From: Amanda Scholes on behalf of Planning.Responses
Sent: 21 December 2020 12:07
To: Planning Scanning
Subject: FW: Planning Consultation on: CM/53/20/PL

App No: CM/53/20/PL
Address: Land at Wren Cottage Horsemere Green Lane Climping BN17 5QZ
Proposal: Development of 2 No 2-bed & 2 No 3-bed detached dwellings & associated works. This site is in CIL Zone 3 and is CIL Liable as new dwellings.

Environment Officer
Environmental Protection
Chichester District Council

SITE PLAN
SCALE 1:500 @ a3

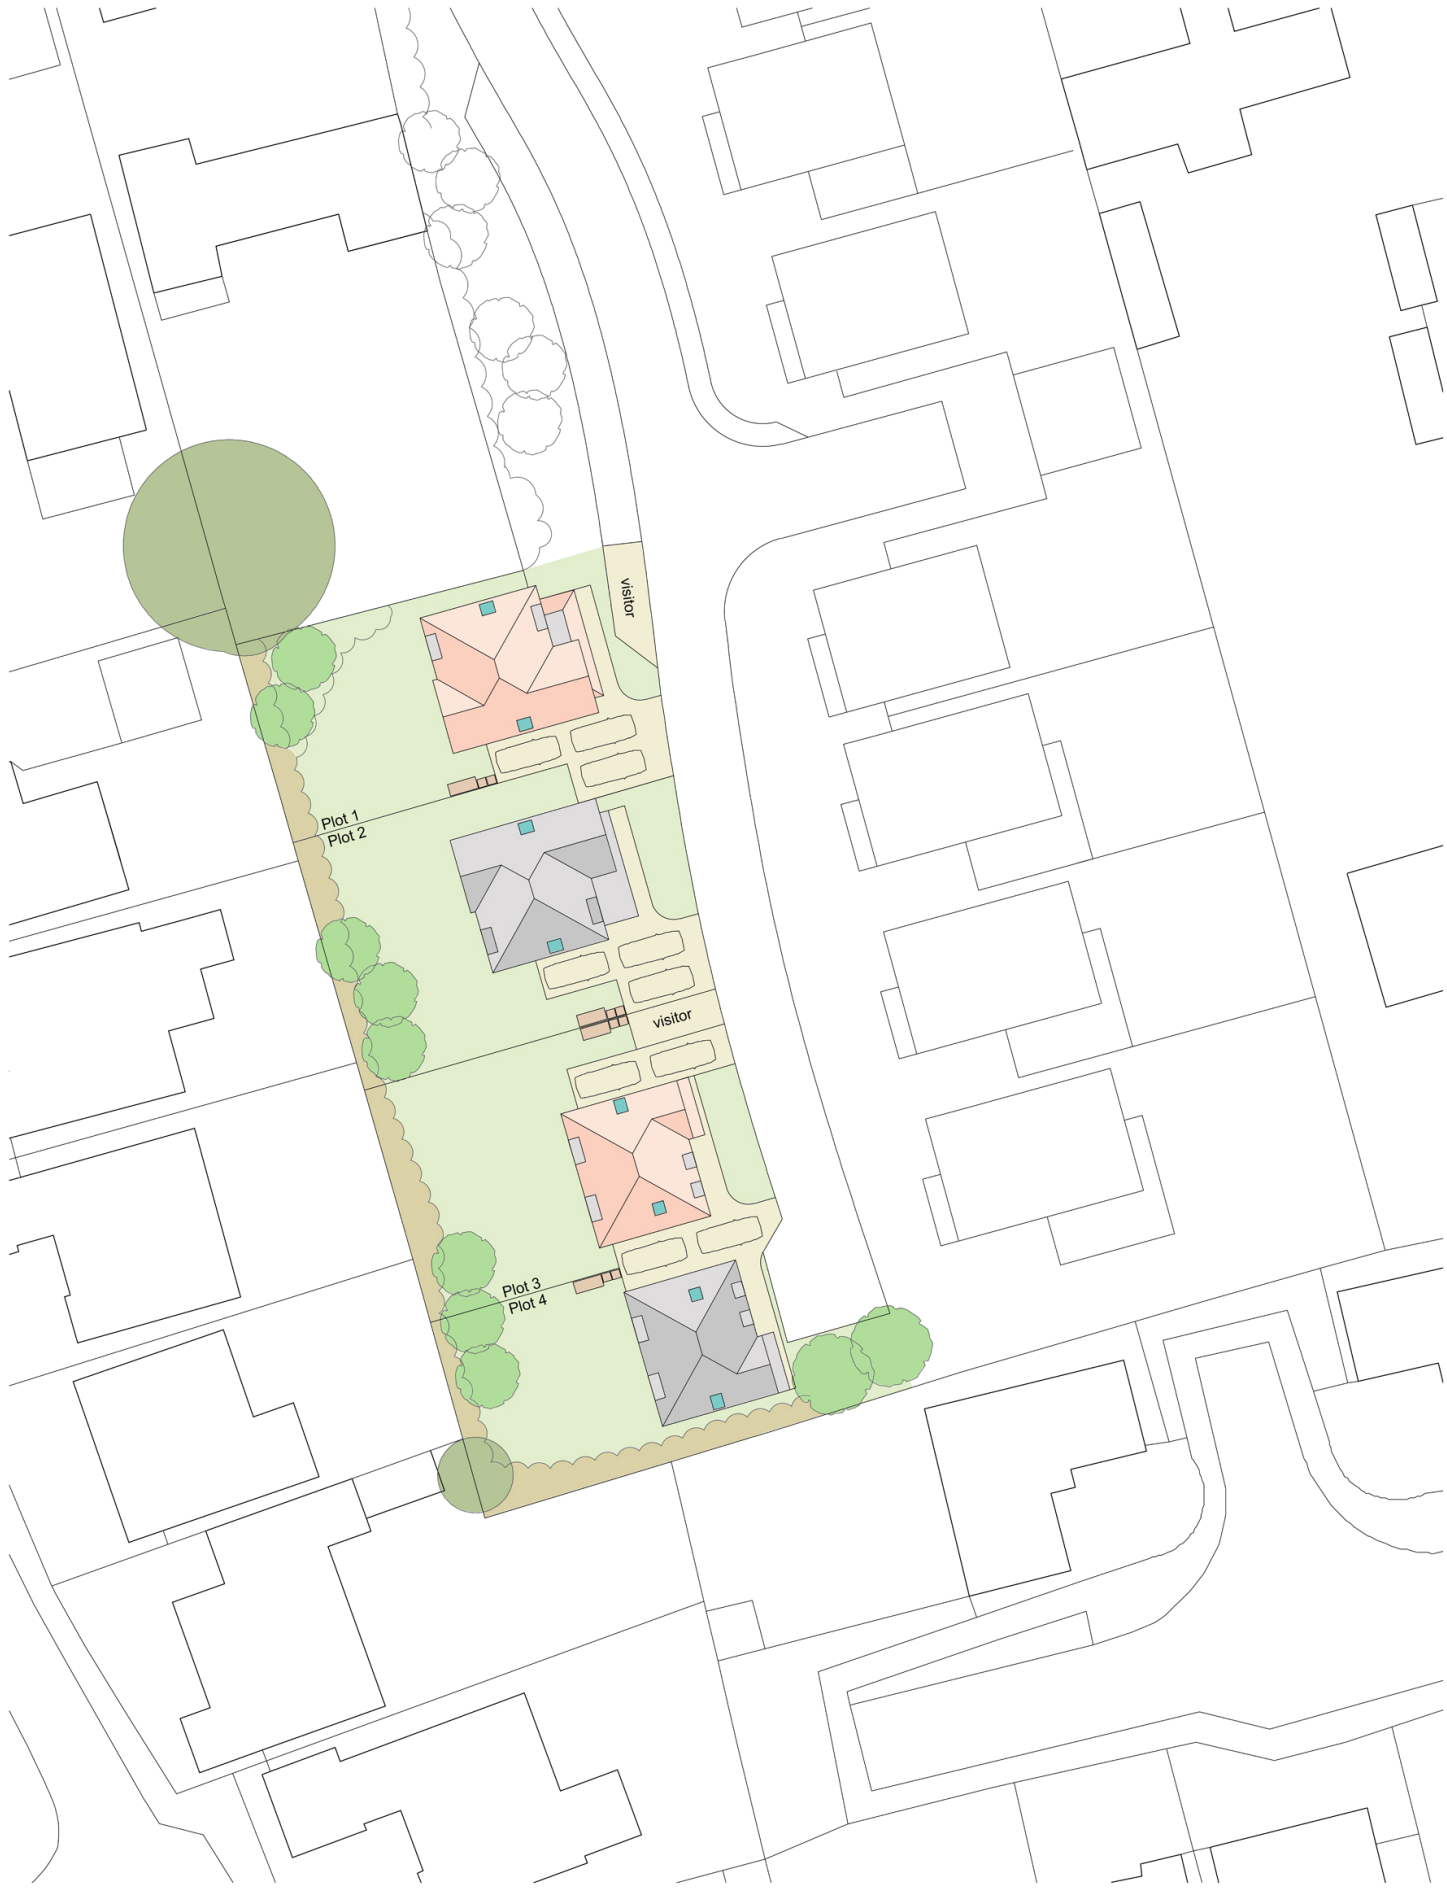
We require that the trees which are currently onsite are retained and protected from harm. If these however need to be removed we require that these area replaced at a ratio of 2:1 to mitigate this.

ECOLOGY ENHANCEMENT PLAN
SCALE 1:500 @ a3

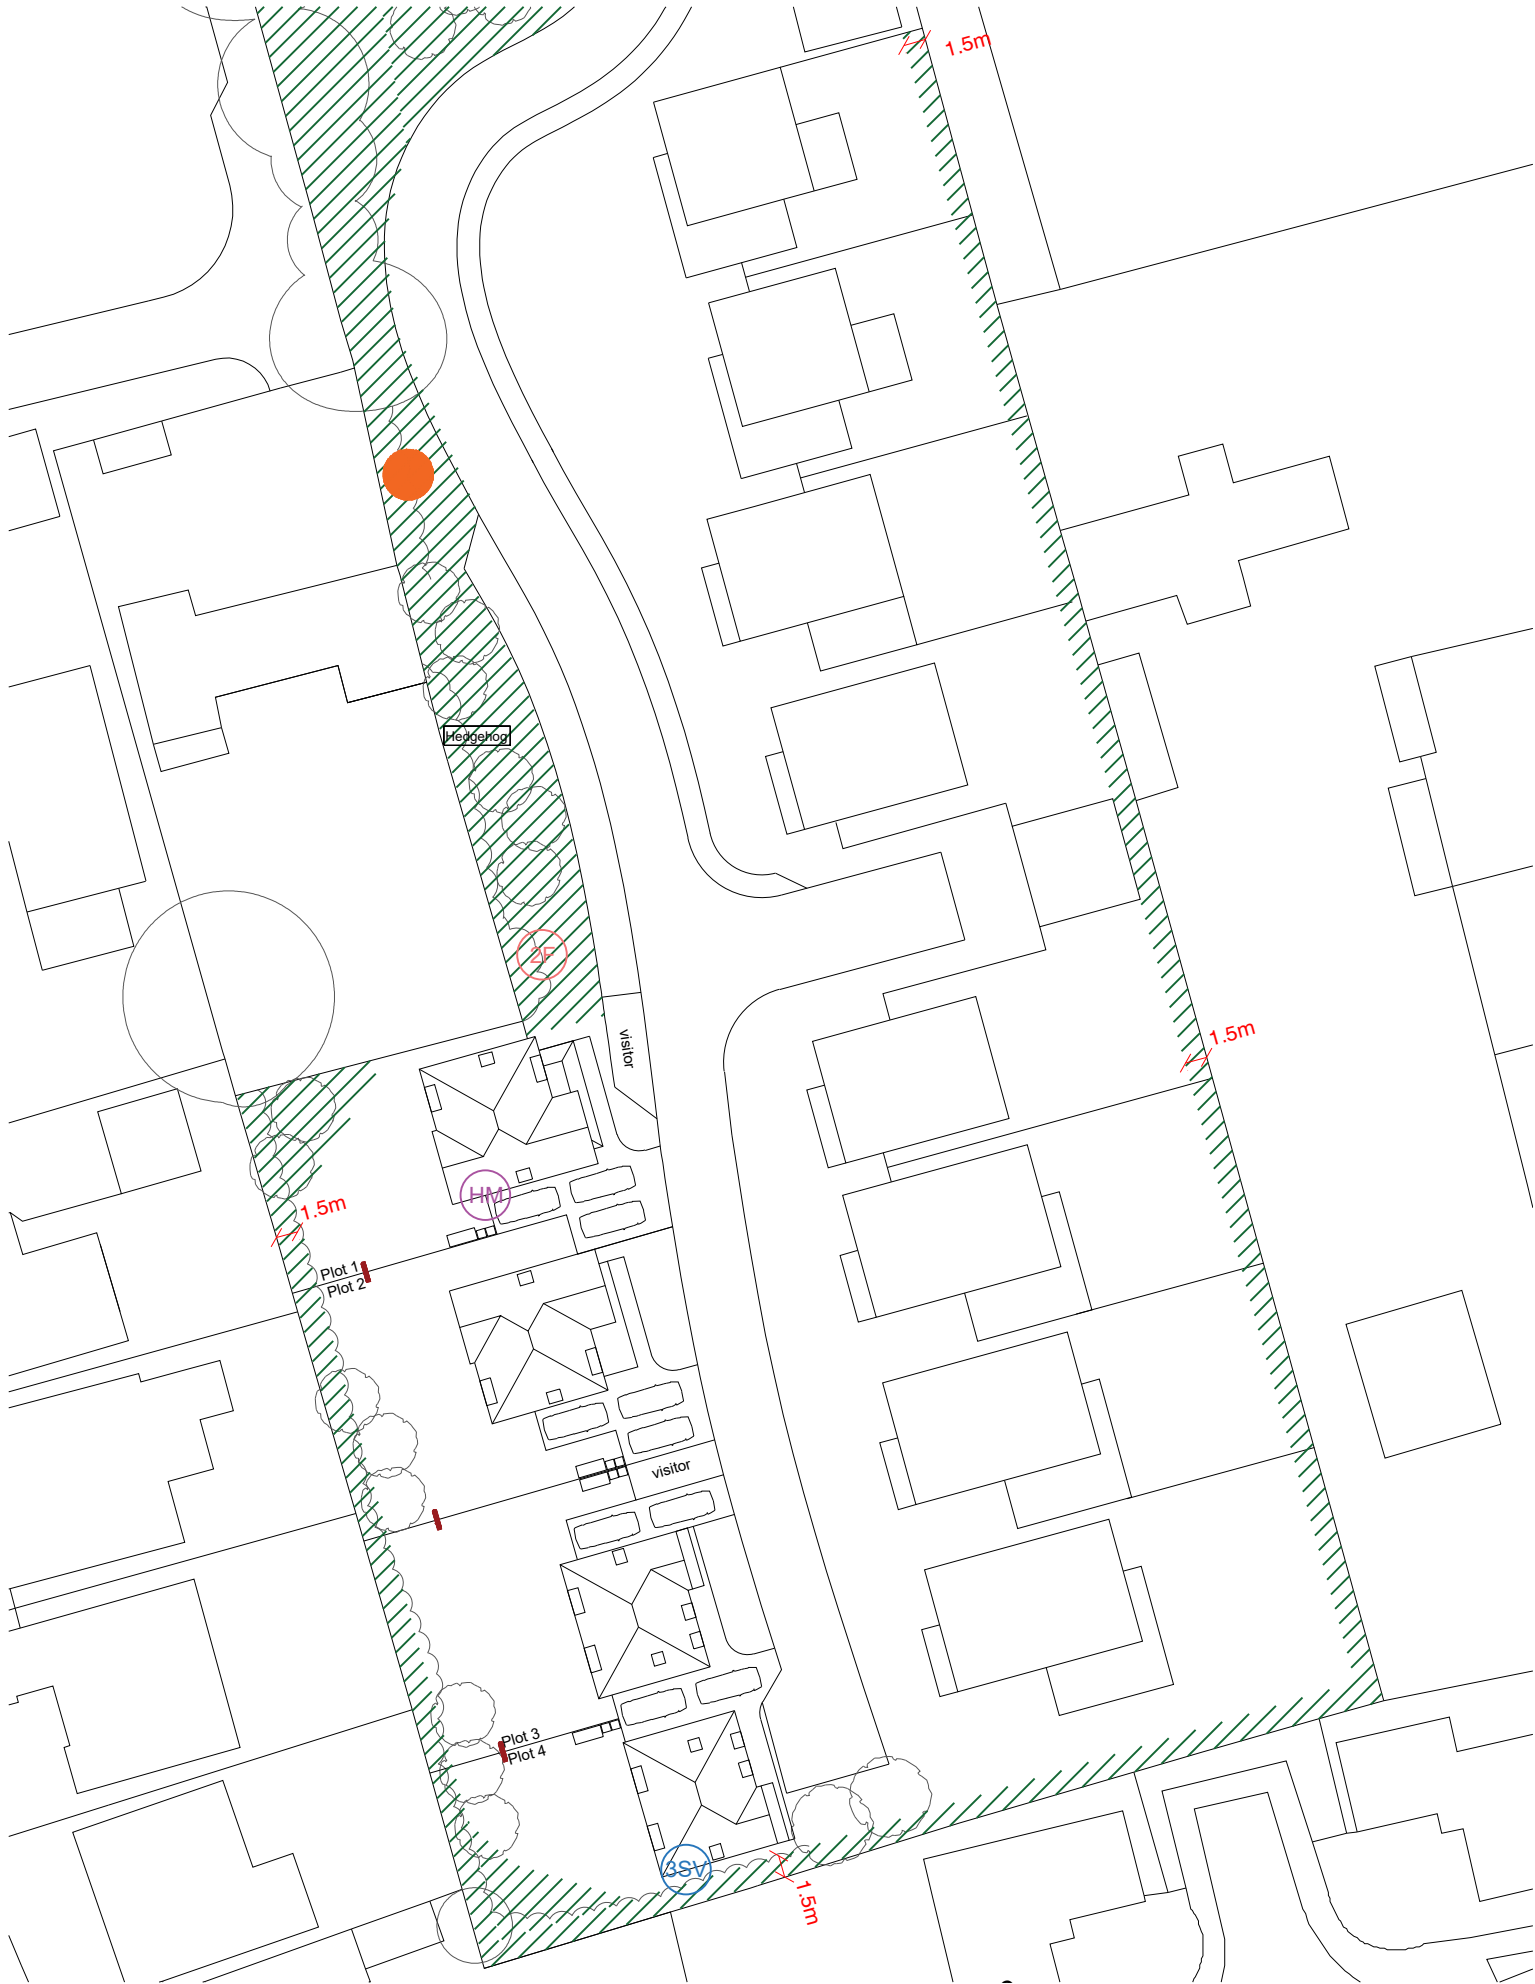
In line with Policy ENV DM5 of the Arun District Local Plan information on Biodiversity Net Gain needs to be provided as part of the planning application prior to determination. We are satisfied that the biodiversity enhancements recommended within the Ecological Enhancement Plan are suitable and should be incorporated into the landscaping scheme. A condition should be used to ensure this takes place.
